App no: 23.0581

Address: Tanner House Farm Higher Ramsgreave Road Ramsgreave

Proposal: Approval of details reserved by conditions 3 (Ground Levels) and 7 (Drainage Strategy) of planning permission 3/2021/1168

Aco & Surfacing Details - 1:20

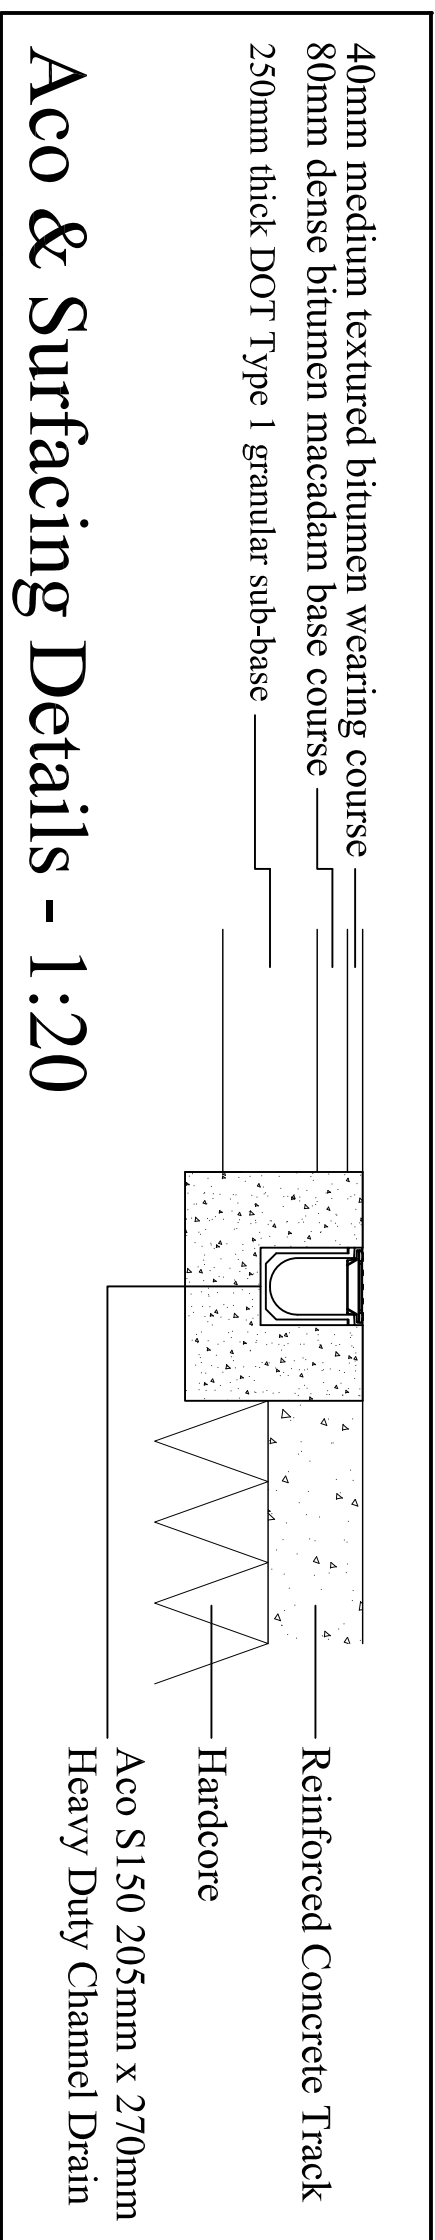
The surface water from the site access will be collected with an aco style drainage channel which discharges to a soakaway in the field.

There is no objection to the discharge of this condition.

Title:		Proposed Land Management Access Track on Saccary Lane at Tanner House Farm, Higher Ramsgreave Road, BB1 9DJ	
Client:		Mrs G. Dunlop	
Scale:	1:20, 1:50, 1:100 @ A1		Drawing number: 1129-01
Date:	13/07/23	Drawn by: JC	Revision:

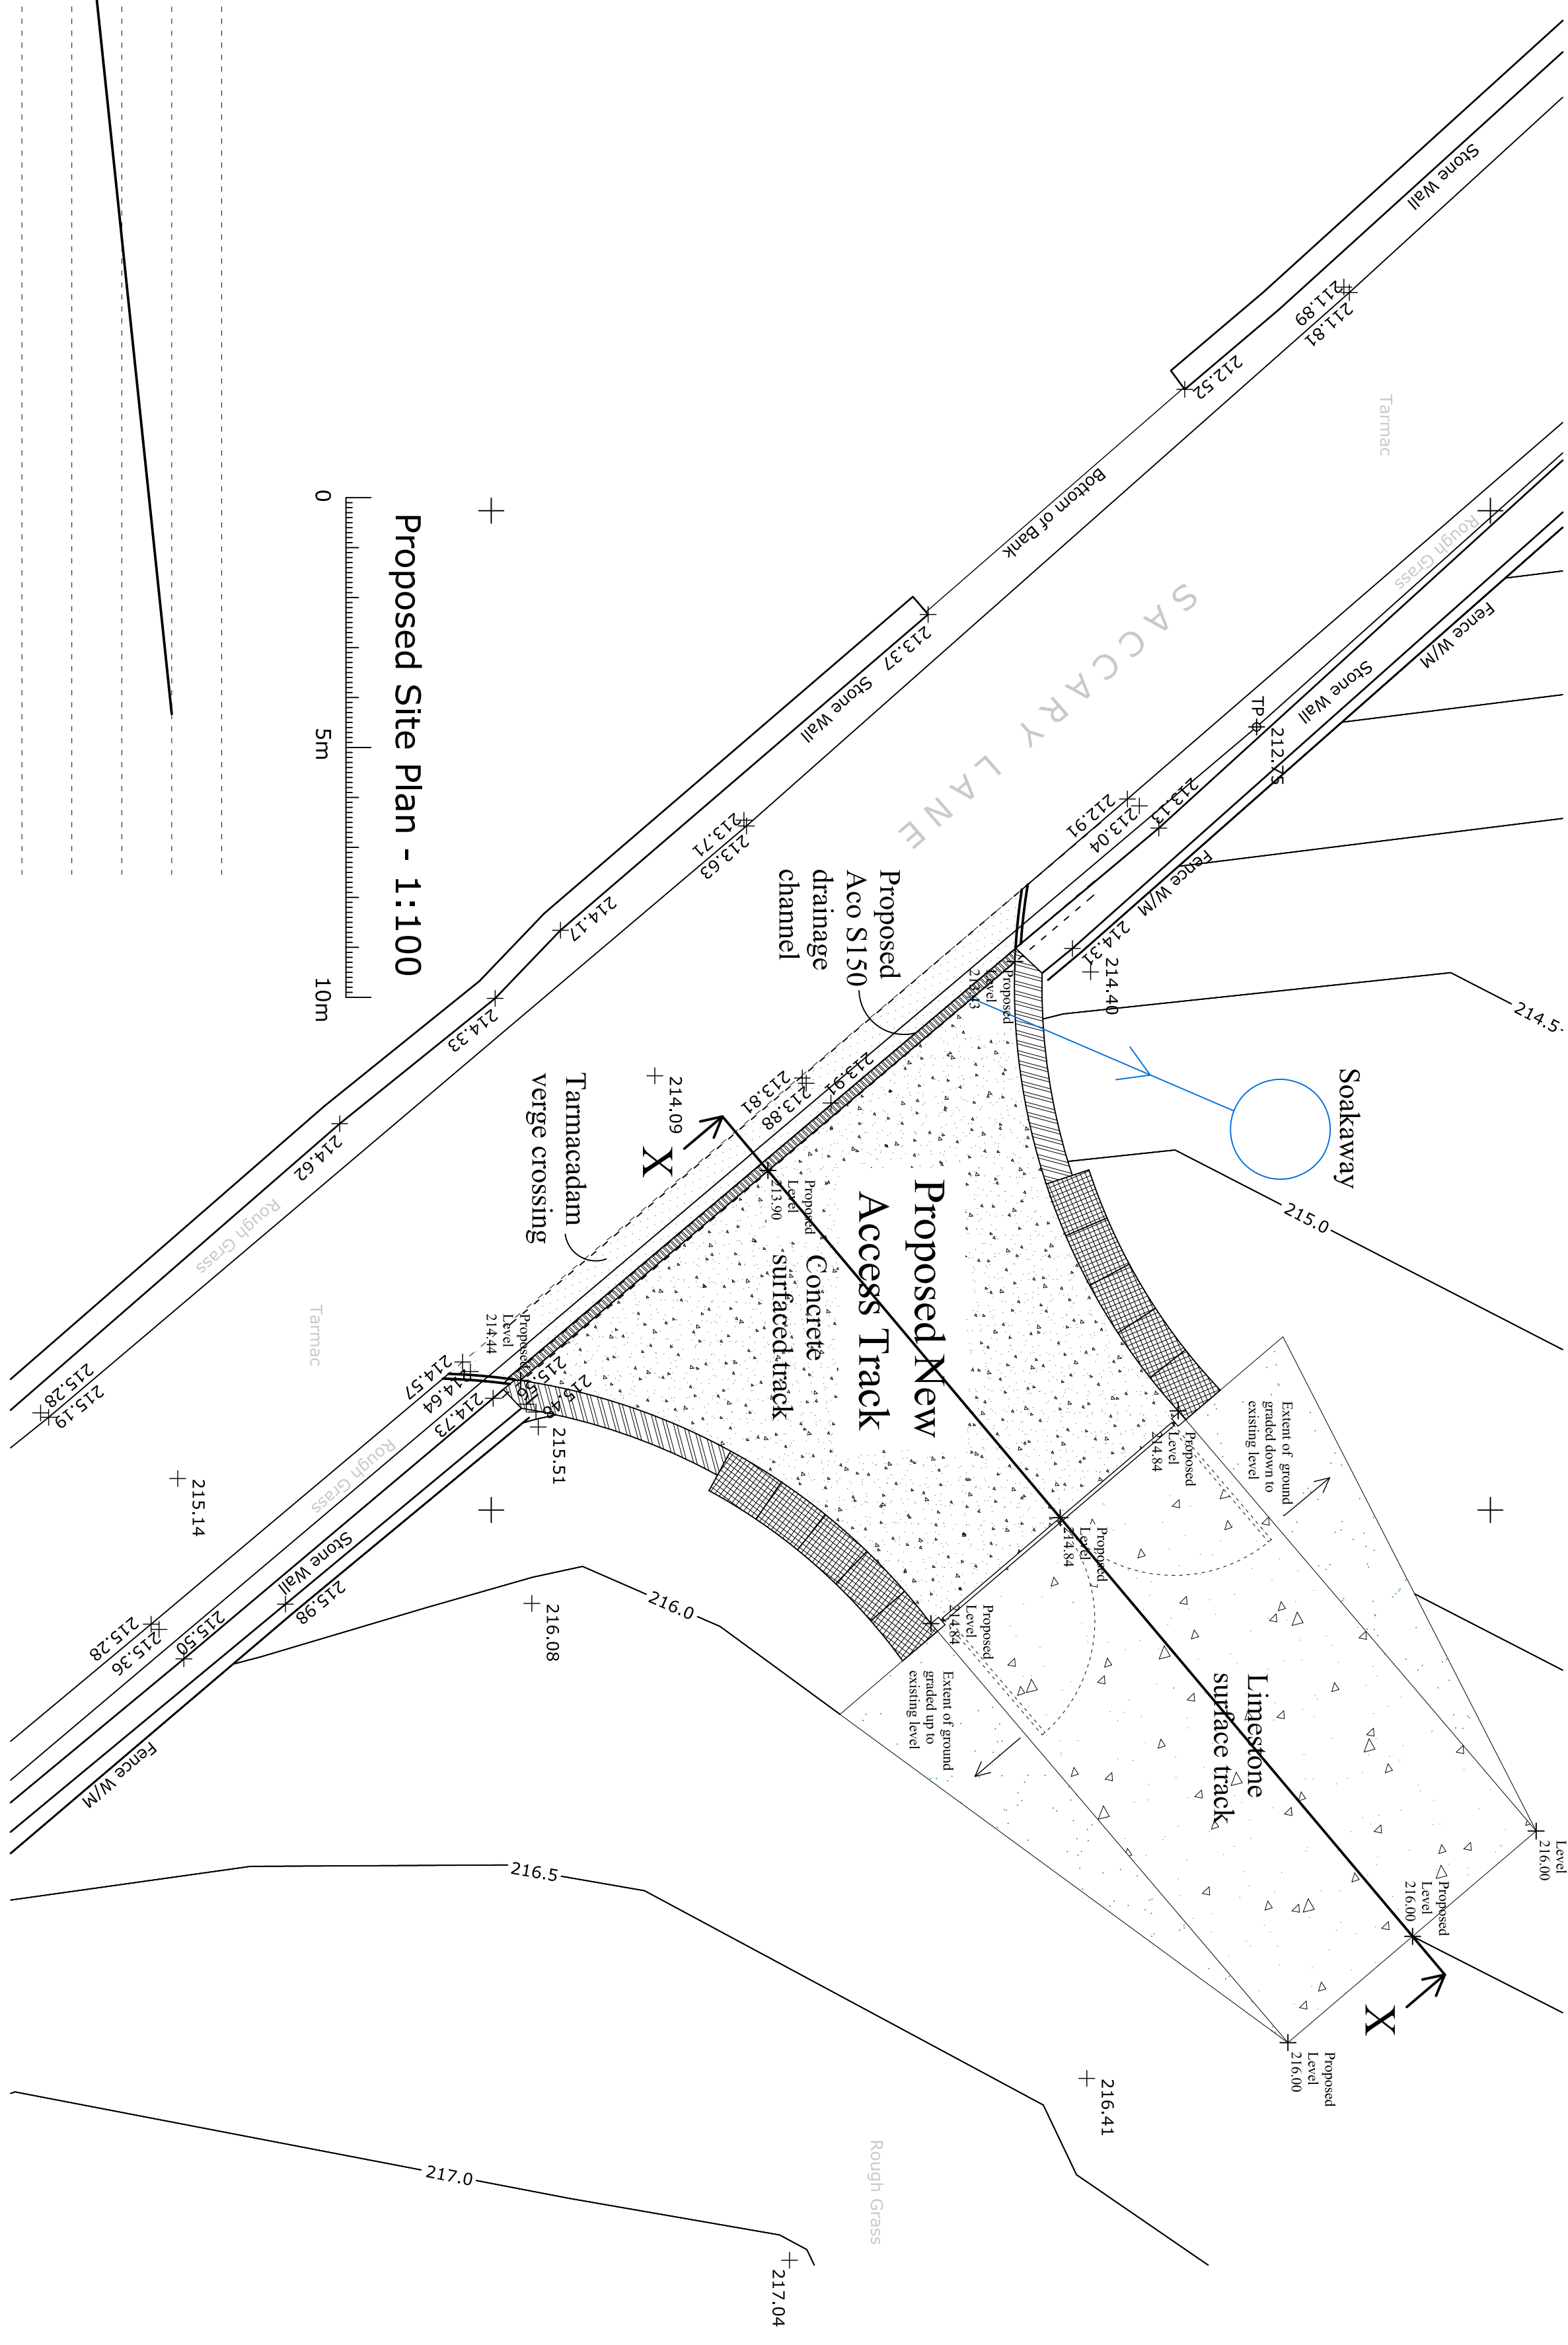
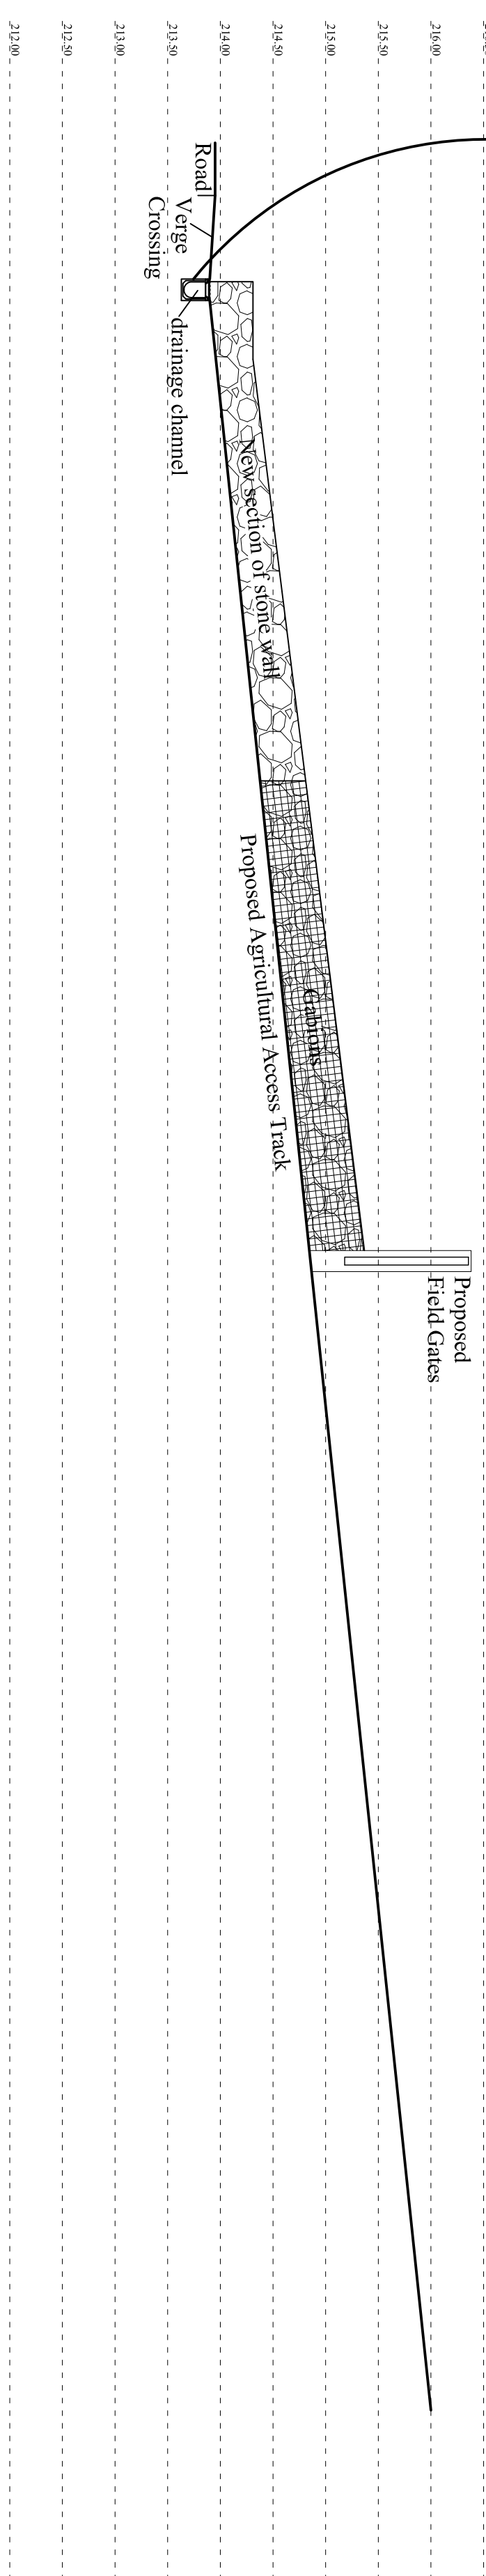
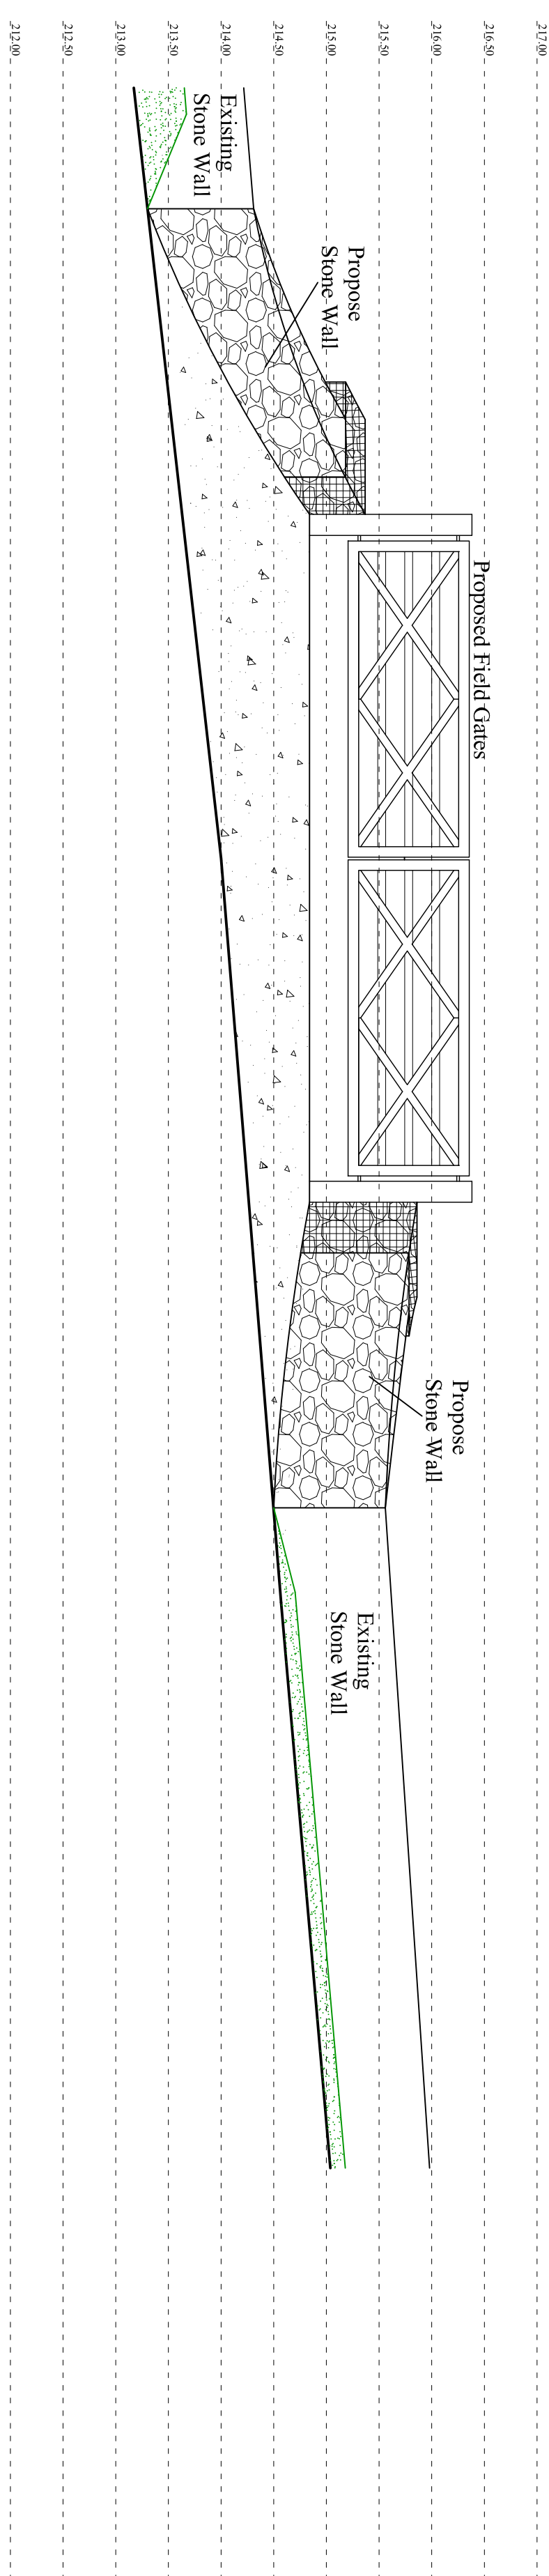
The Highway Authority notes that the site access will be at a gradient of 1:10 due to the topography, which is the steepest that we would expect to see.
